DECISION DELEGATED TO HEAD OF PLANNING

Application No: H09-0233-22 **Applicant:** Mr S Norris

Proposal: Extension & Conversion of Existing Garage into Self Contained Dwelling with Detached Garage to Host Dwelling - re-submission of H09-0045-21

Location: 78 Chestnut Avenue Holbeach Spalding

Plan 01 - Ground
1 : 50

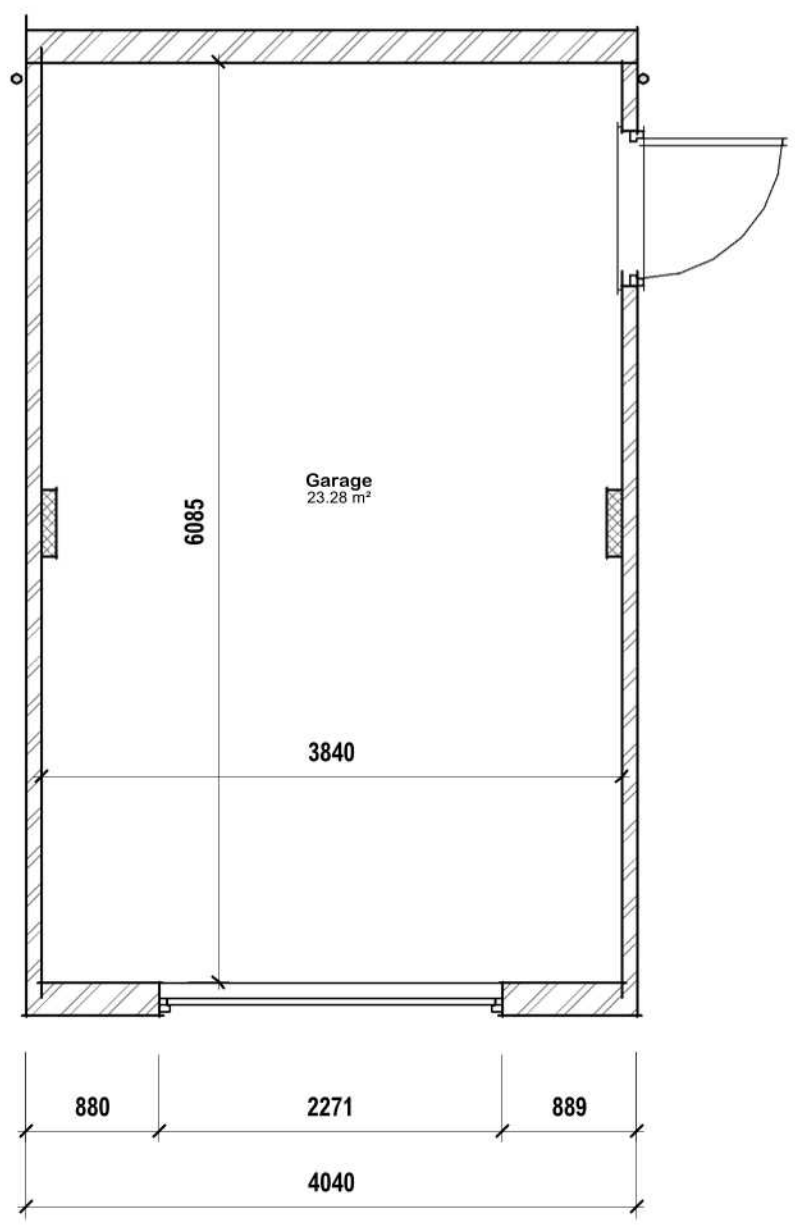
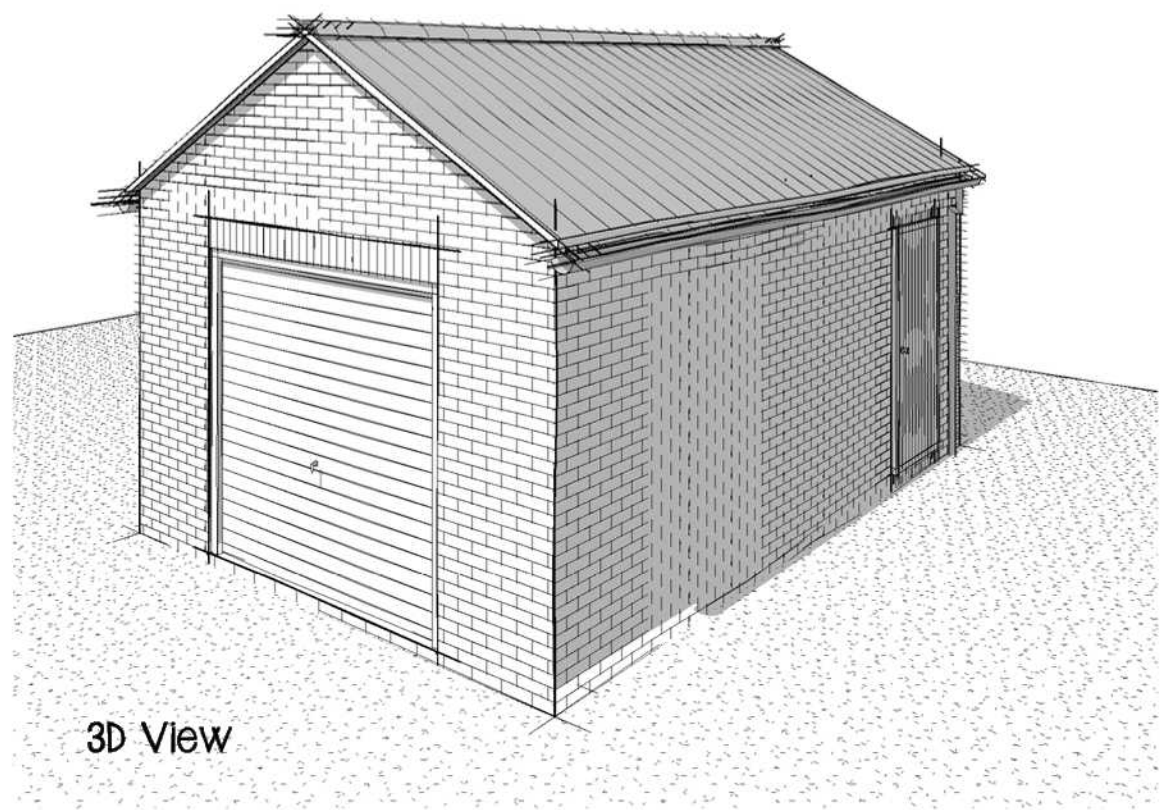
It is considered that the proposal would constitute an unacceptable form of cramped development which is out of keeping with existing development in the area by virtue of existing residential development being sited within larger plots. The proposal would result in a much smaller plot which is out of character with the prevailing density of the area and to the detriment of the existing character and appearance of the area.

Furthermore, the private garden would be provided to the front of the property heavily concealed by closeboard fencing. The proposals would not ensure natural surveillance between the private and public spaces nor adequate amenity standards to the future occupiers when enjoying the garden.

Concerning condition (b), The site-specific flood risk assessment that accompanies this application recommends that finished floor levels for single storey buildings with bedrooms on the ground floor must be at least 3.75 ODN which is 260mm above the existing level of the garage. No evidence has been provided to demonstrate that the proposal would soundly achieve sustainable development which is required to allow new development in high flood risk areas.
